CITY OF PORTLAND

BUILDING PERMIT

Job ID: 2010-12-93-ALTR

has permission to Change Use from a Two to a Single Family Residence/ Exterior Deck Construction.
provided that the person or persons, firm or corporation accepting this permit shall comply with all of the provisions of the Statues of Maine and of the Ordinances of the City of Portland regulating the construction, maintenance and use of the buildings and structures, and of the application on file in the department.

Back deck - Replaced old structure, same footprint

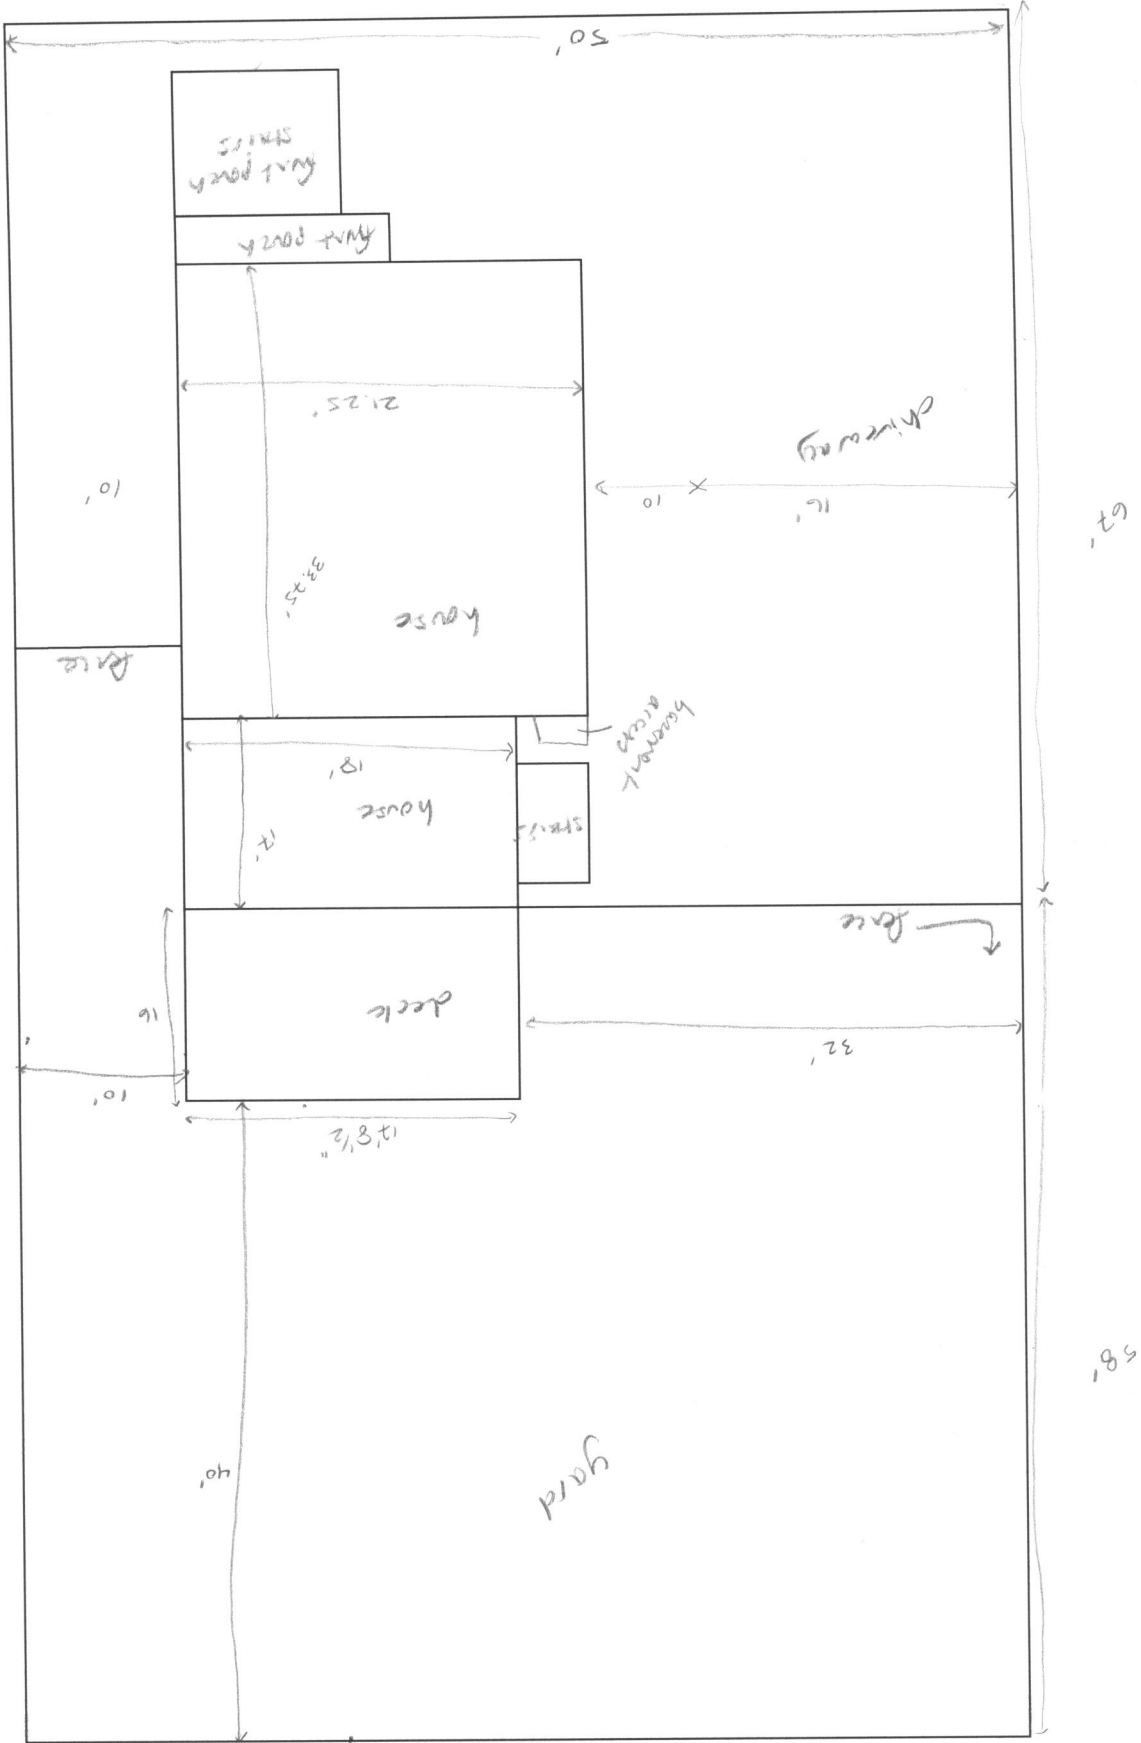
1. Separate permits shall be required for future decks, sheds, pools, and/ or garages.
2. This property shall remain a single family dwelling with the issuance of this permit and subsequent issuance of a certificate of occupancy. Any change of use shall require a separate permit application for review and approval.
3. This permit is being approved on the basis of plans submitted. Any deviations shall require a separate approval before starting that work.
4. It is understood that the kitchen on the 2nd floor will be removed in its entirety.
5. It is further understood that the rear deck will be replaced in the footprint area shown on your submitted plans.

2. The basement is NOT approved as habitable space. A code compliant 2nd means of egress must be installed in order to change the use of this space.
3. The existing deck shall be inspected for adequate fasteners and bearing for spans, and modifications may be required.

5. A graspable handrail (34-38 inches in height) shall be provided on at least one side of each continuous run of treads or flight with four or more risers. Fall protection from exterior decks may be required if floor joist are at or above thirty (30) inches from grade.

8. R311.5.1 Attachment. Exterior landings, decks, balconies, stairs and similar facilities shall be positively anchored to the primary structure to resist both vertical and lateral forces or shall be designed to be self-supporting. Attachment shall not be accomplished by use of toenails or nails subject to withdrawal.

Site plan, 85 Fessenden street

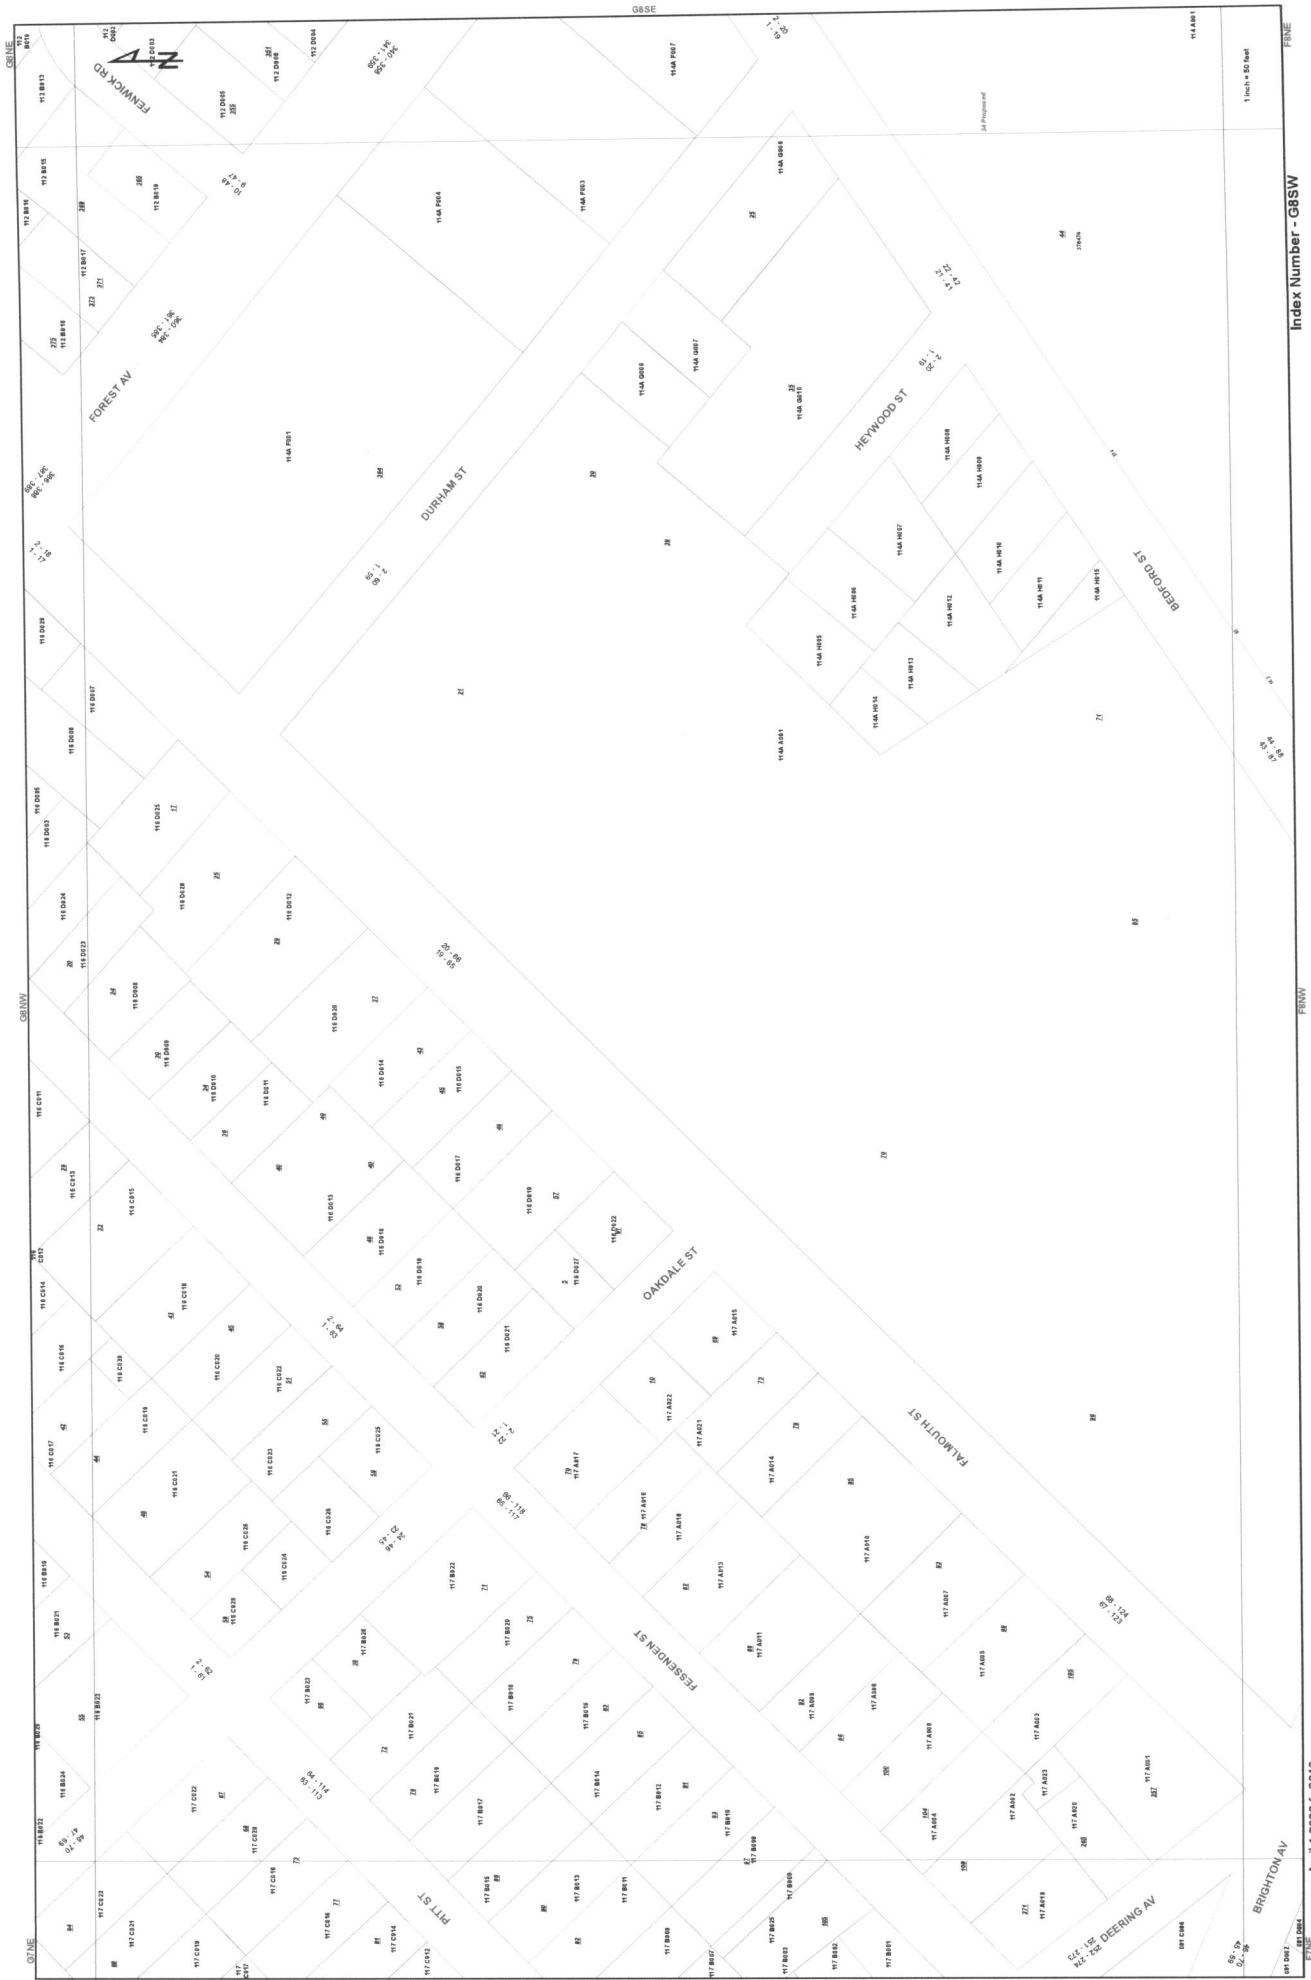
R-5
REAR 20' req - 40' show
FRONT - N/A
SIDE 1 story 8' min - 10' give
ok
